14 April 2016

Roads and Maritime Reference: SYD15/01299/02 (A12427334)
Department's Ref: SSD 7317

**RE-DEVELOPMENT OF THE AUSTRALIAN TECHNOLOGY PARK
LOCOMOTIVE STREET, EVELEIGH**

TOTAL CAR SPACES:
Lower Ground (93 spaces) + Mezzanine (60 spaces) + Upper Ground (64 spaces) = 217 car spaces

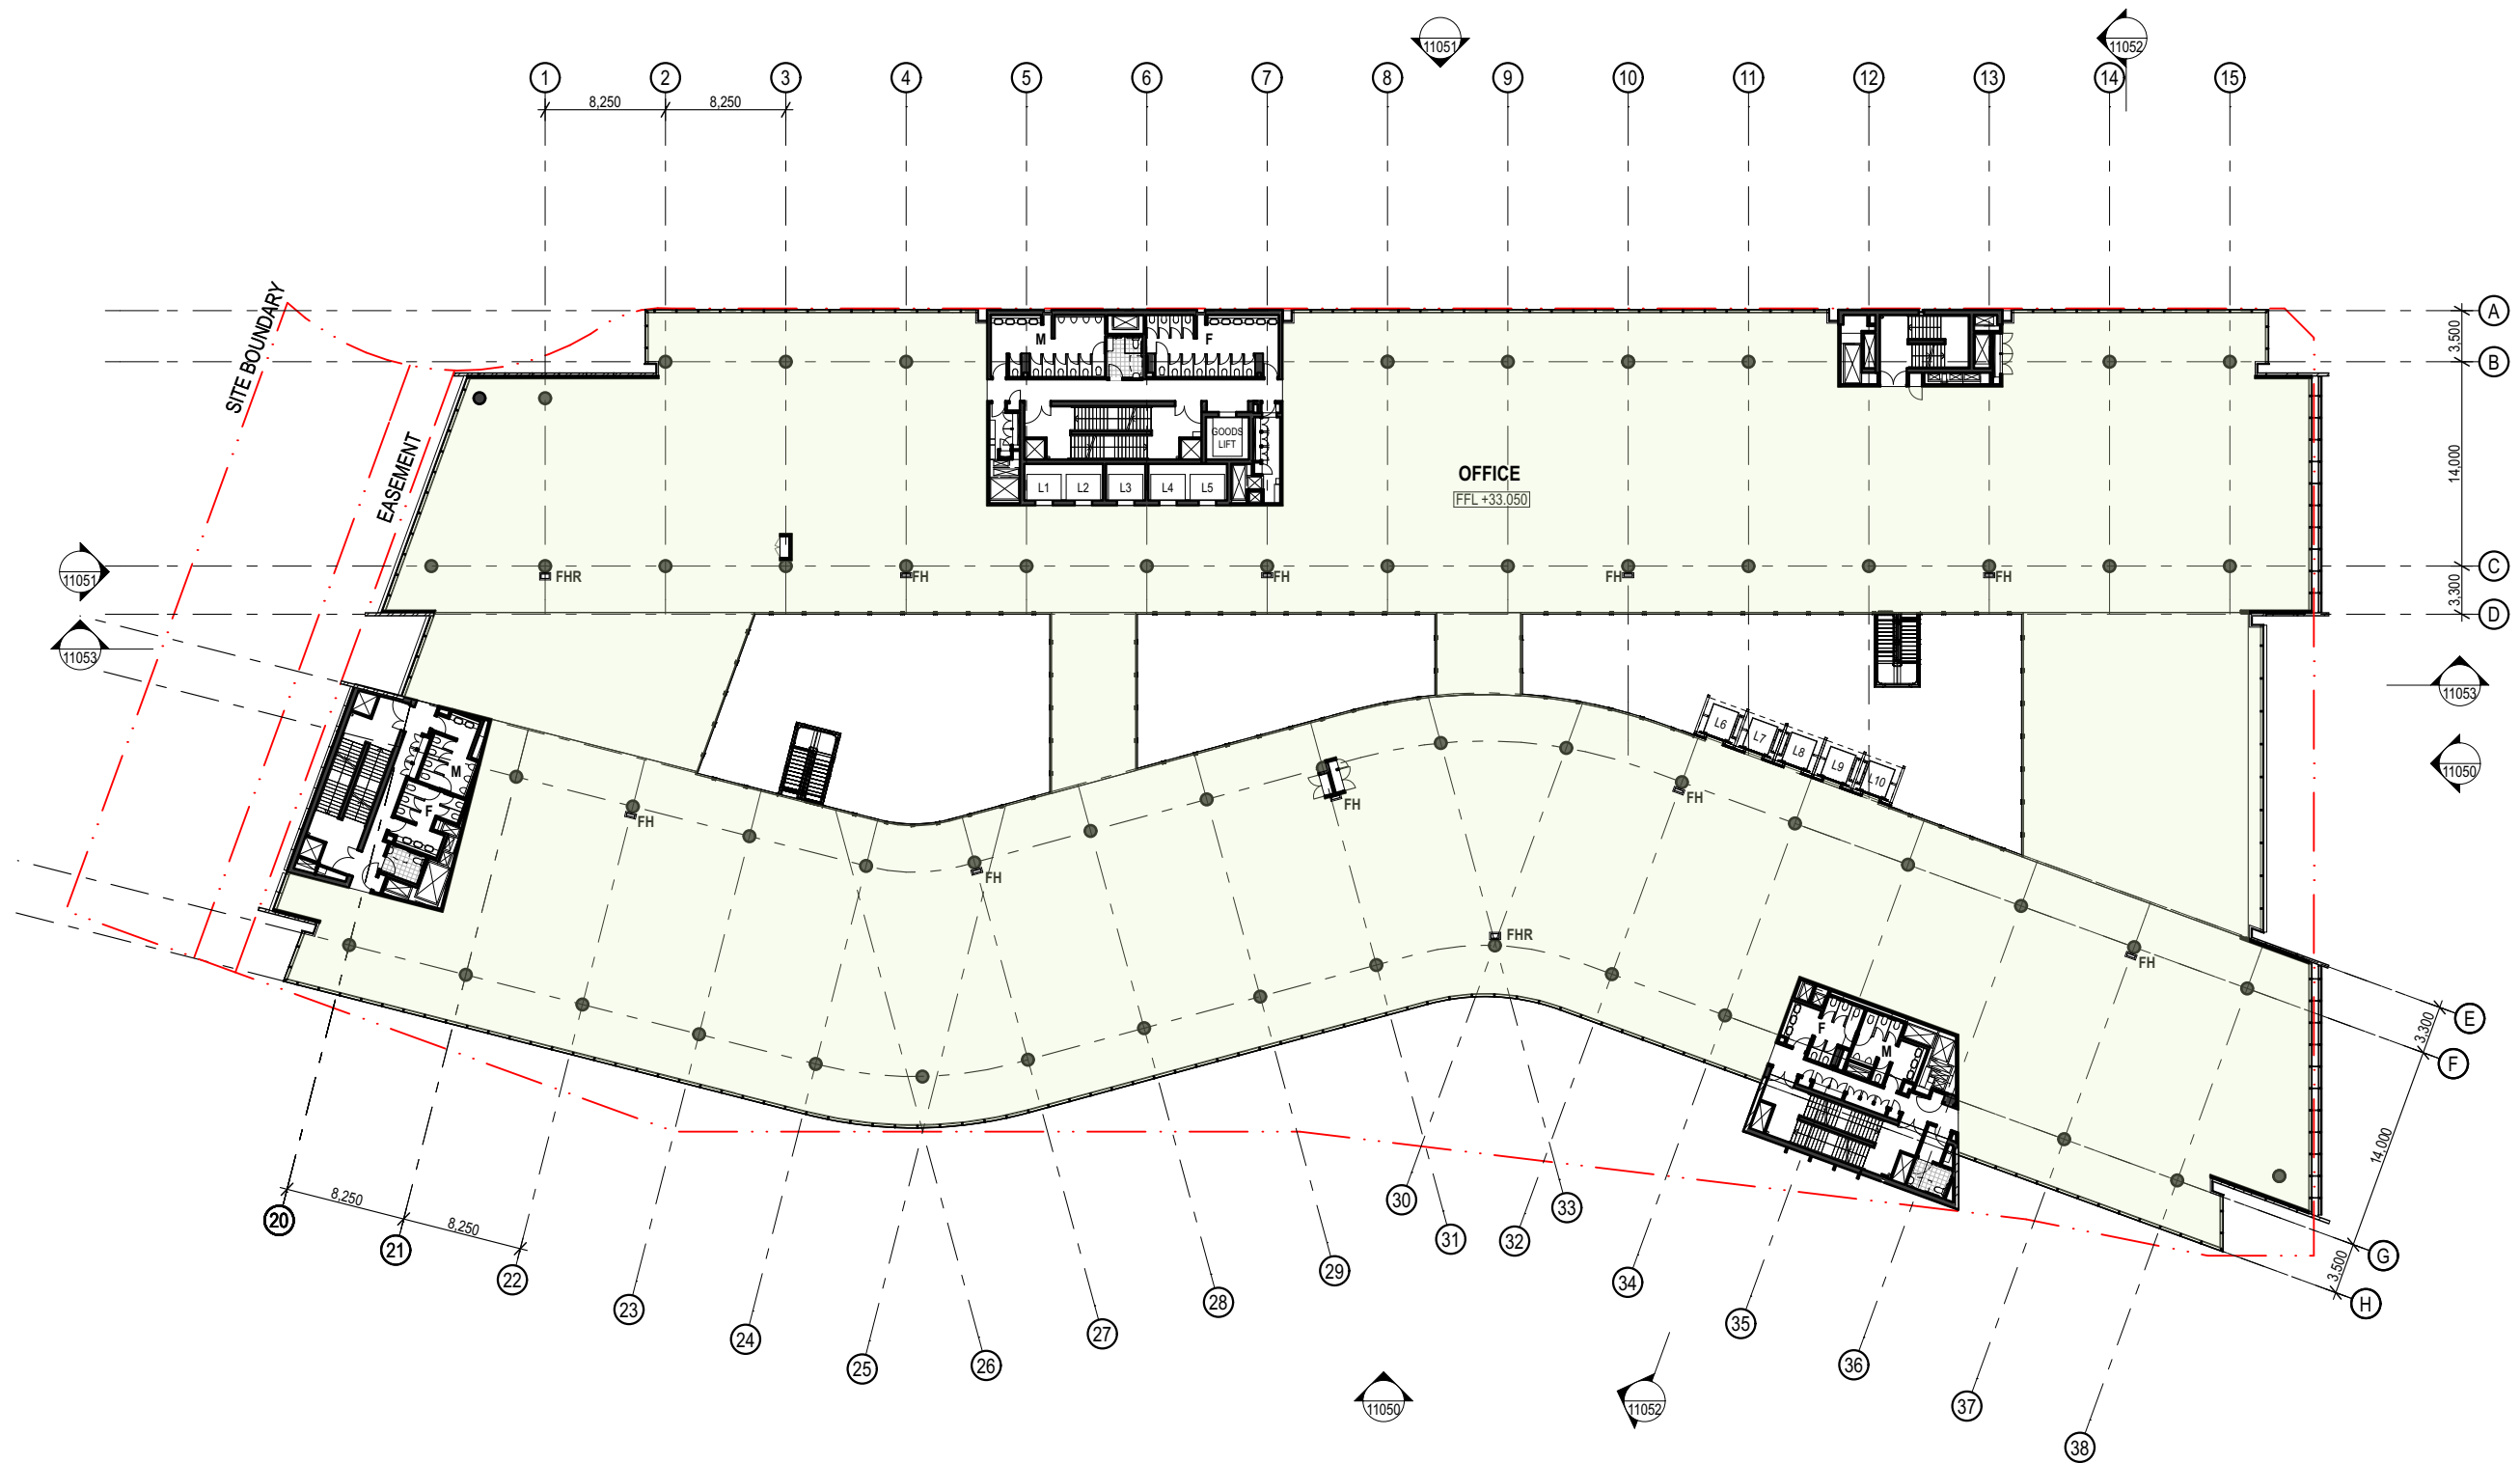
4. The childcare facilities for both the Community Building and Building 1 will generate a need for short term visitor parking close to the facilities. The traffic generation of these childcare centres has not been separately assessed and it is not clear how this parking provision is to be managed.

5. Loading facilities or accessible parking has not been considered for the Community Building, however with the expected uses of the building, such facilities would be required.
